Town & Country Planning Act 1990 (as amended)
Town & country Planning (Development Management Procedure) (England) Order 2015
Application for Planning Permission for Works or Extension to a Dwelling

Development Replace windows with double glazed. Installation of photovoltaic panels. Installation of 2No. velux windows. Proposed porch. Remove redundant second chimney. Minor reconfigurations to doors & windows & partial rendering to match existing.

Location Craig Rock Cottage 28 The Drive Aldwick

I regret that I am unable to accept your documents as a formal application until the following item(s) have been received or resolved :-

BLOCK PLAN
SCALE 1:200

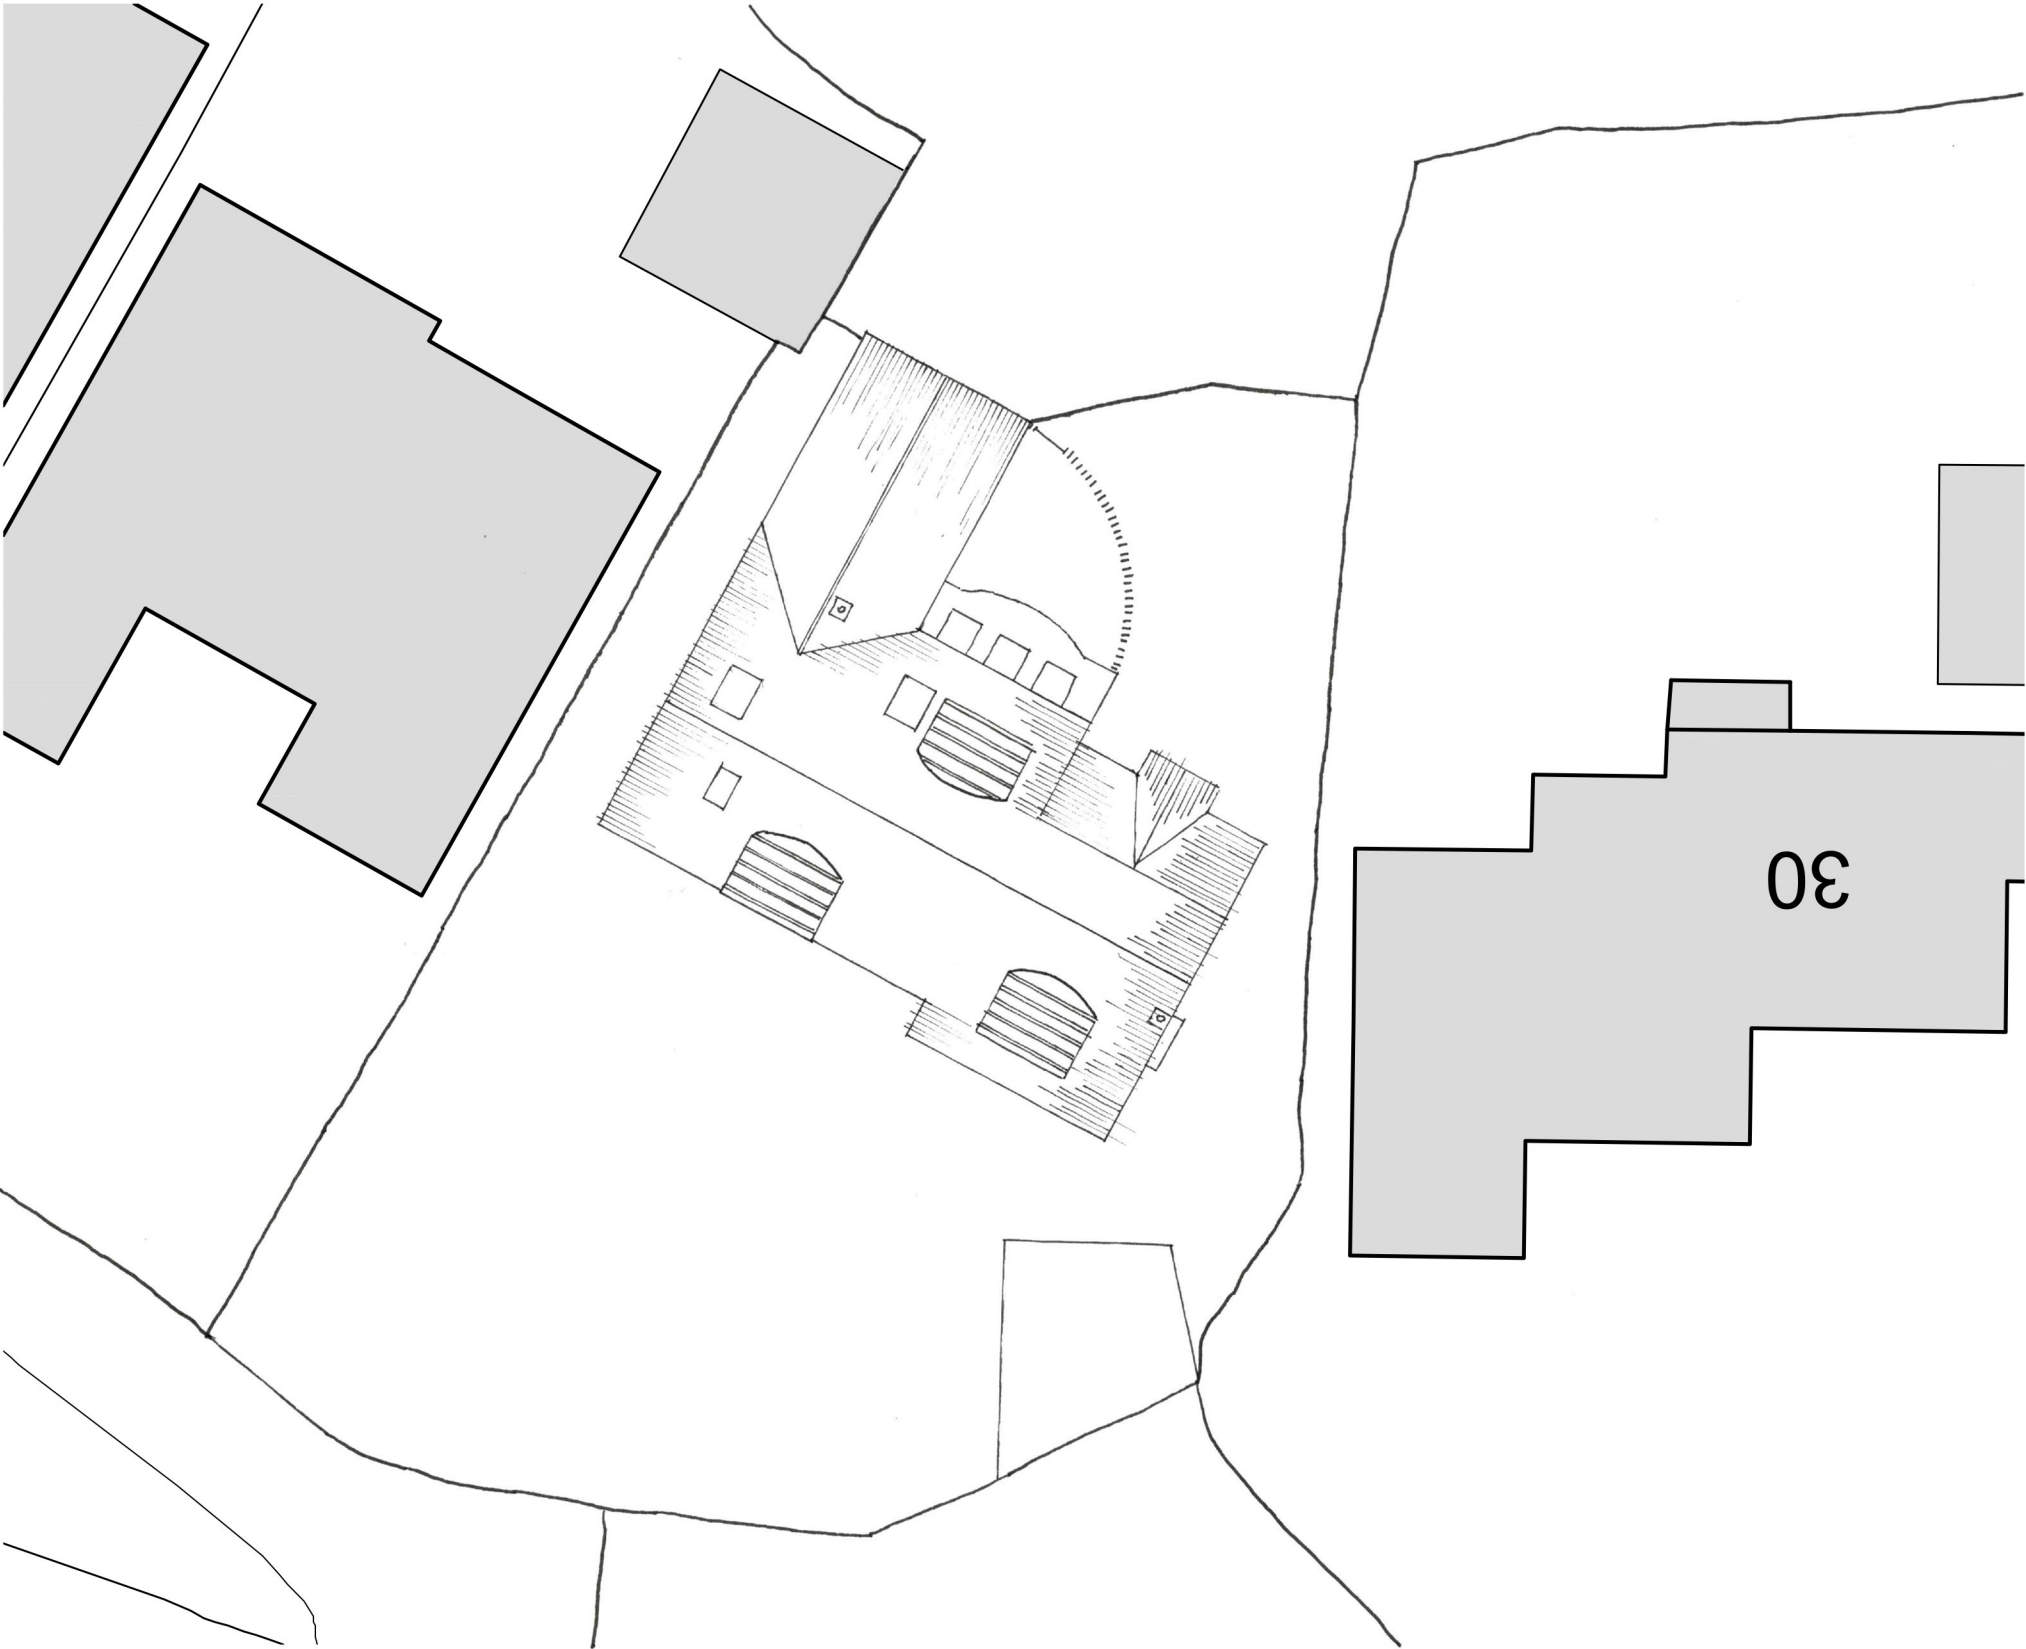
Block Plan - revised

Please submit 1 electronic or 3 paper copies of a revised block/site plan at a scale of 1:500 or 1:200 will all proposed works clearly hatched or highlighted (you may wish to use arrows to indicate the elevations affected by the replacement windows). Also please include 1 named road. Further details of what must be included on the plan can be found in the National Validation Requirements.

Please note there appears to be a shed indicated on the Block plan that has not been included within the application form. Please confirm if this is to be considered as part of the application, if it is not then please remove from the Block plan. However if it is then please make sure it is included within all of the proposed floor plans and elevations.
